**RE: Evans Park PRD, 17909 25<sup>th</sup> Ave NE  
1<sup>st</sup> technical review comment response letter  
Permit #: PA22-003**

Please refer to our responses below which address all review comments received from you via email on April 11, 2022. You will find the markup comments listed in the order that they were written followed by our response in *italics*.

EVANS PARK PRD/BSP

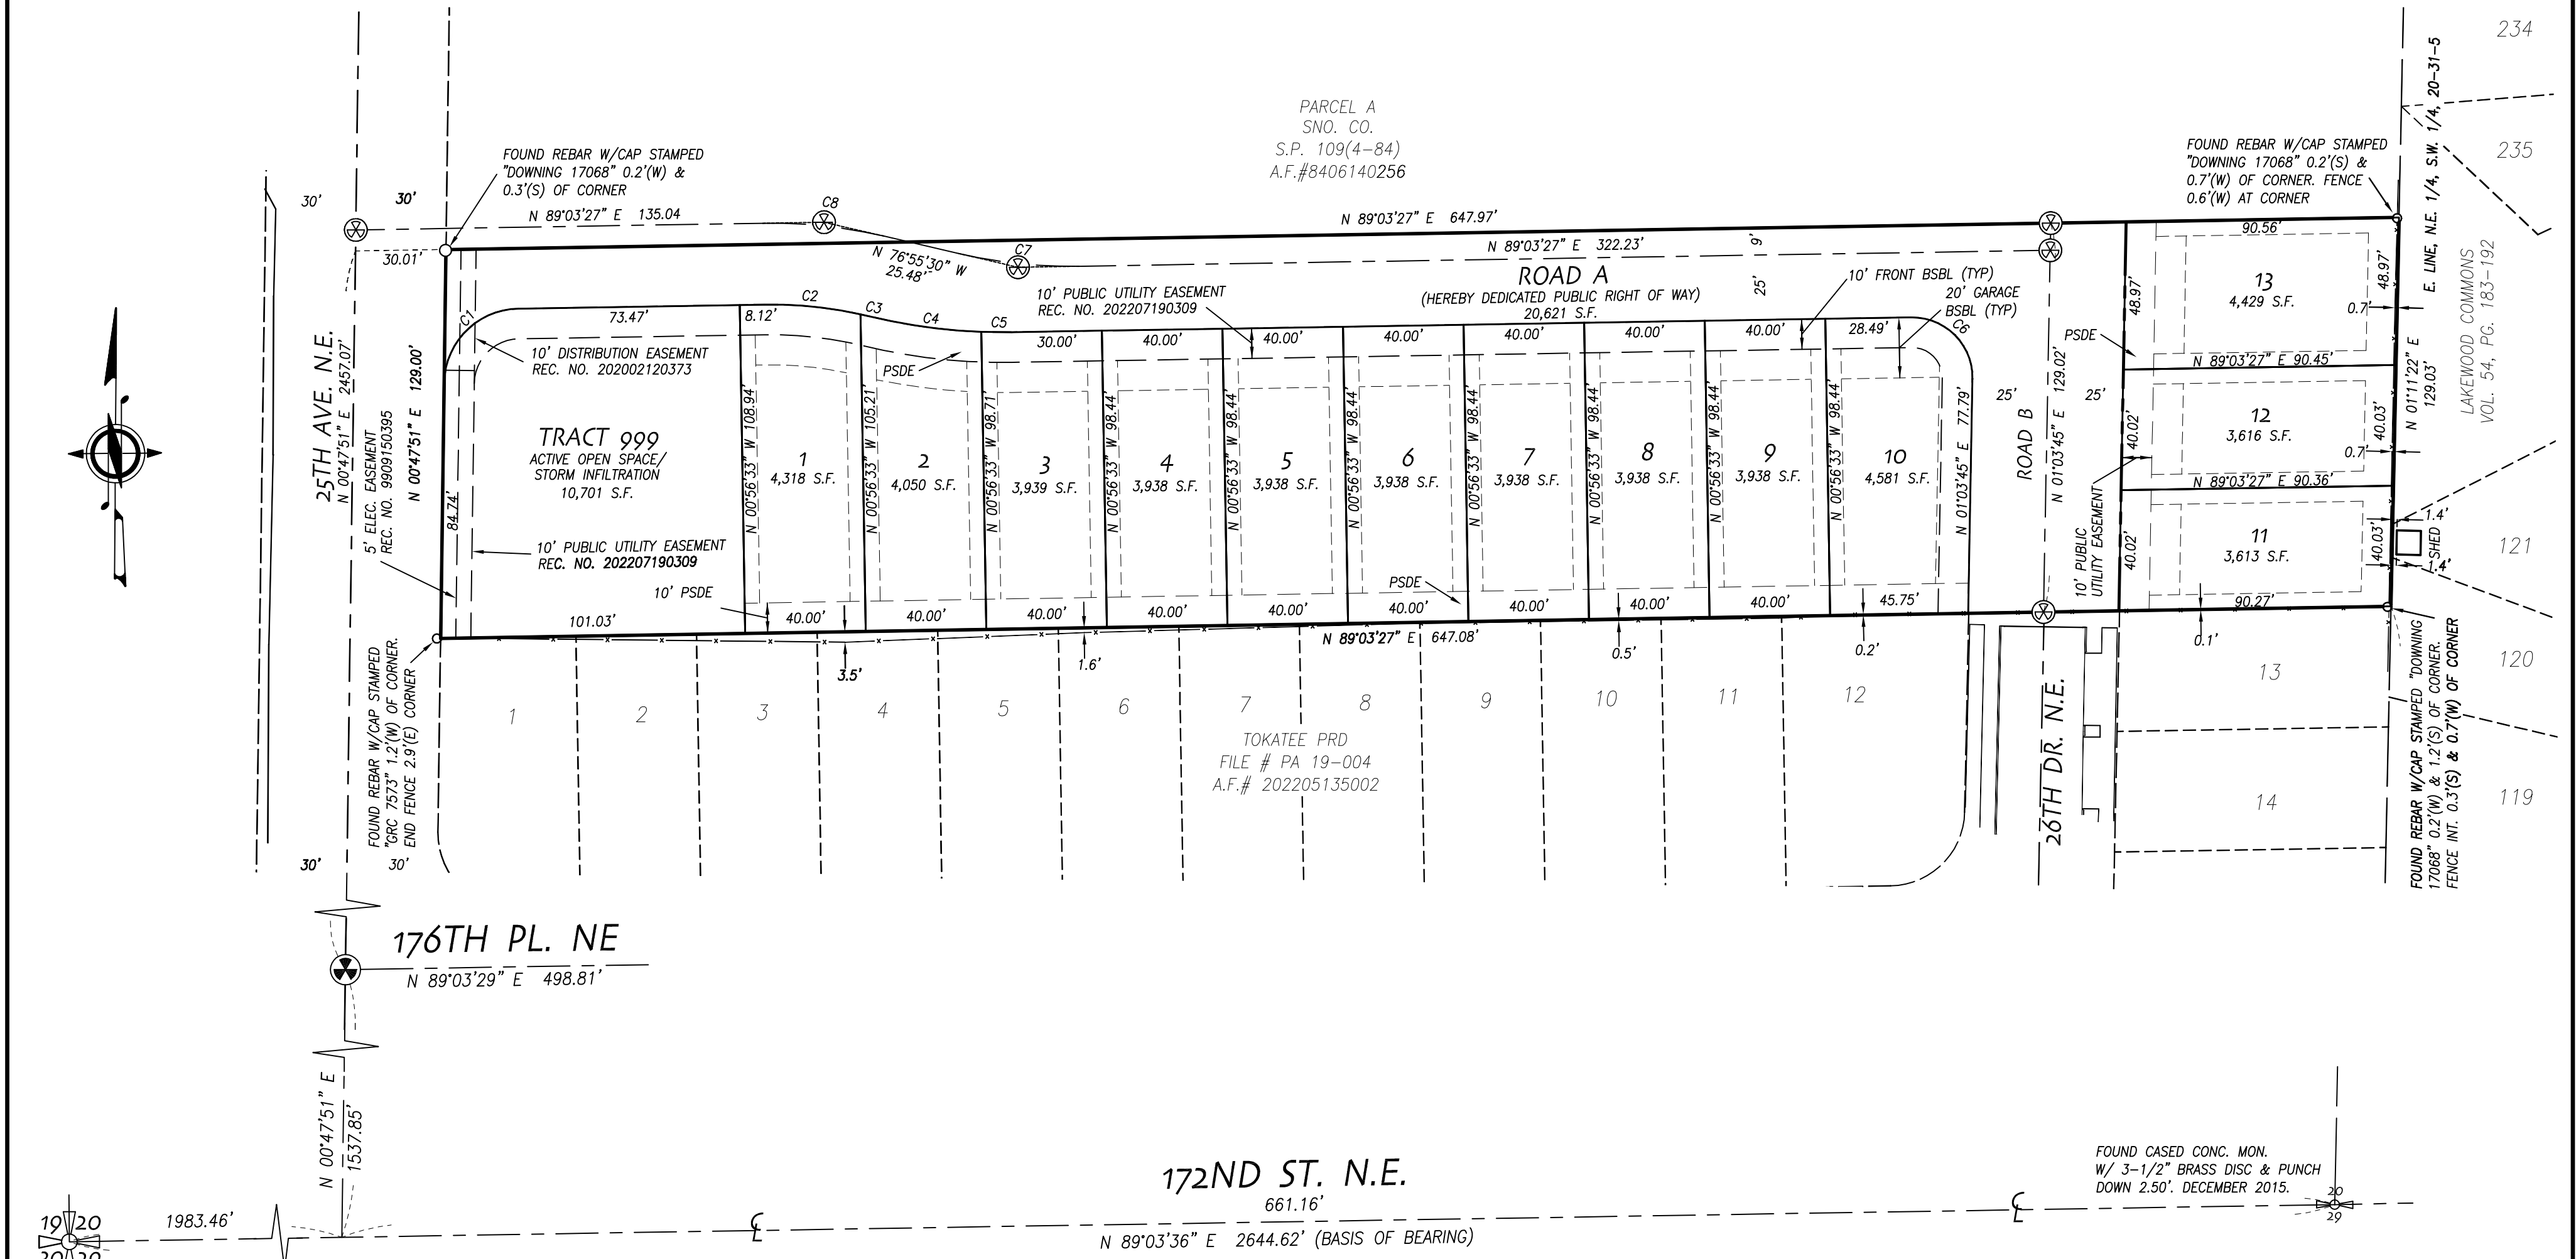
1. Please depict all easements on the plat map (AFN's 9909150395, and 202002120373).

2. Please add file number PA22-003 to map

***Response: All easements are now shown in the topographical survey, including the referenced easements.***

***Response: File number has been added to all sheets as requested.***
